City of Albuquerque Stormwater Construction Site Inspection Report

Project Name:	Valle de Atrisco				
Location:	9901 Ceja Vista Rd SW				
Site Contact Name & Agency	Trevor/ Trevco Inc.	ESC File No.	P09E002D		
	505-2386215	NPDES Id. No.	NMR1001TV		
Inspection Date:	02/25/19	Start/End Time:	0815/0900 hrs		
CoA Stormwater Inspector:	Timothy Sims, Stormwater Inspector				
Present Phase of Construction:	Foundations, footings				
Type of Inspection:	<input checked="" type="checkbox"/> Regular	<input type="checkbox"/> Storm Event	<input type="checkbox"/> Post Storm Event >0.25"	<input type="checkbox"/> 311/Complaint	<input type="checkbox"/> Follow Up

VALLE DE ATRISCO
EROSION & SEDIMENT CONTROL PLAN

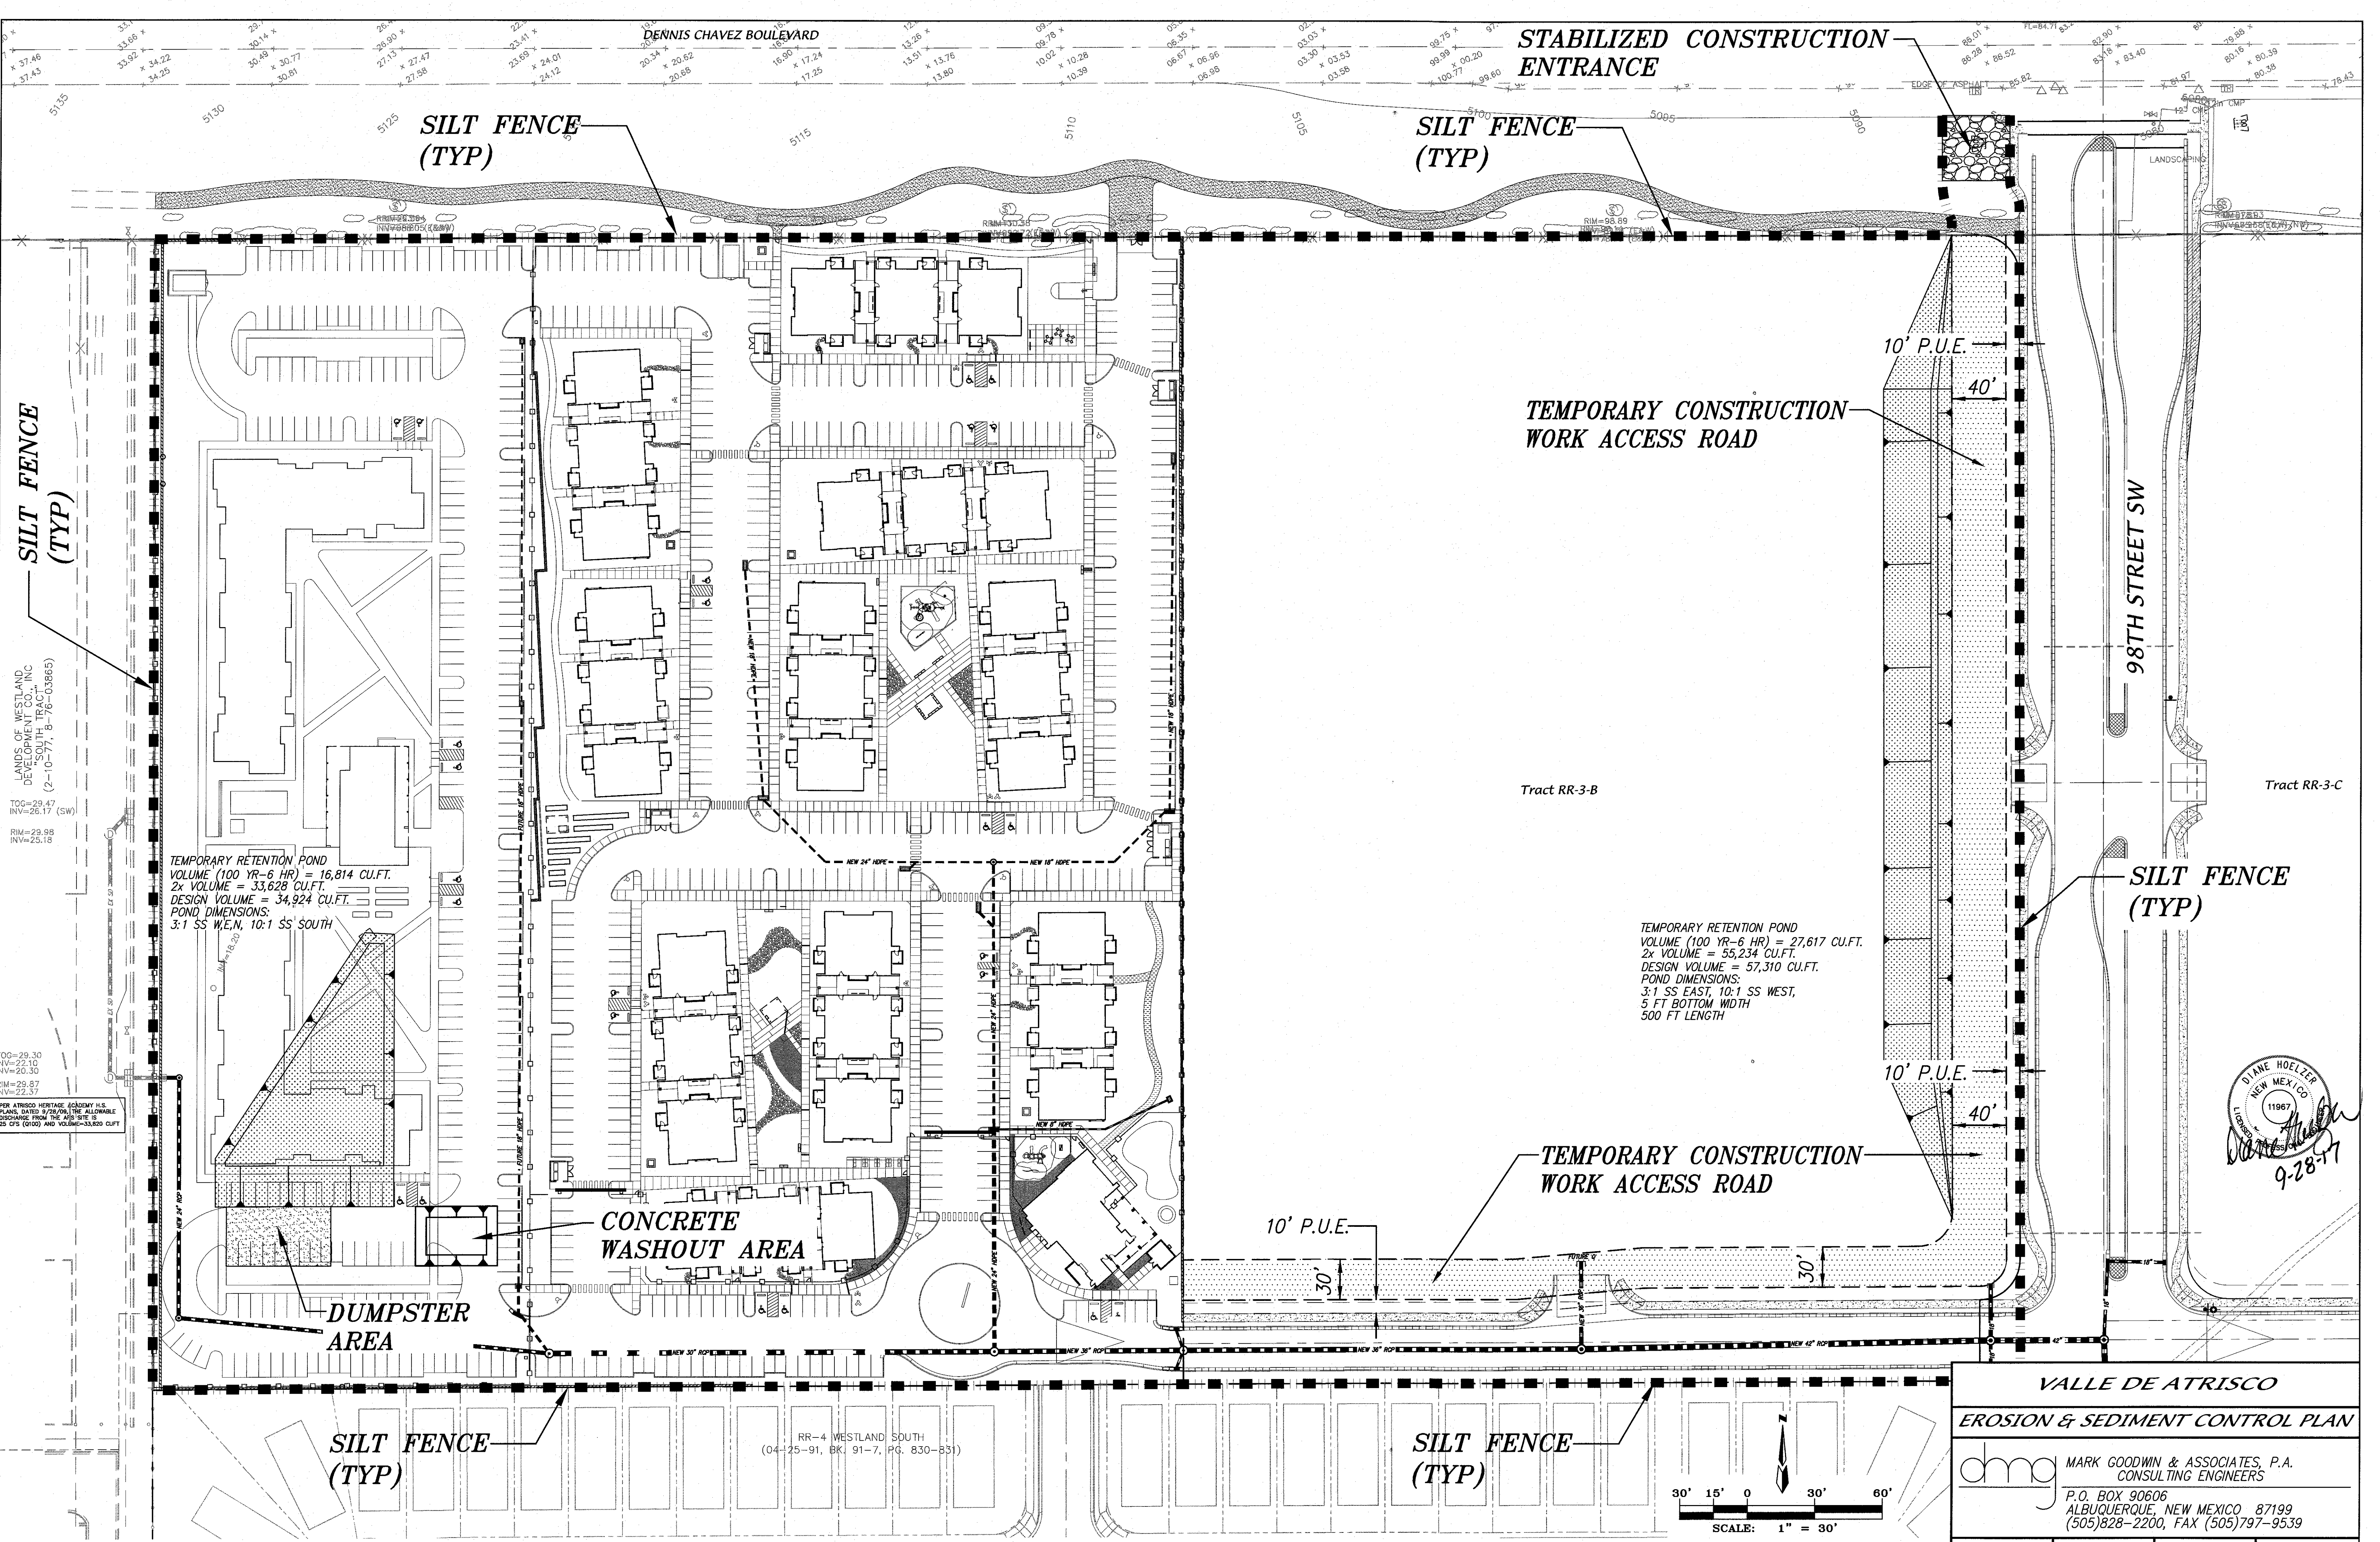
2.2.3	Sediment control along any perimeter	x	East silt fence needs maintenance, cleaning
2.2.3	Sediment control along any perimeter	x	Repair silt fence as needed

Maintenance or corrective actions are to be completed within seven (7) days.
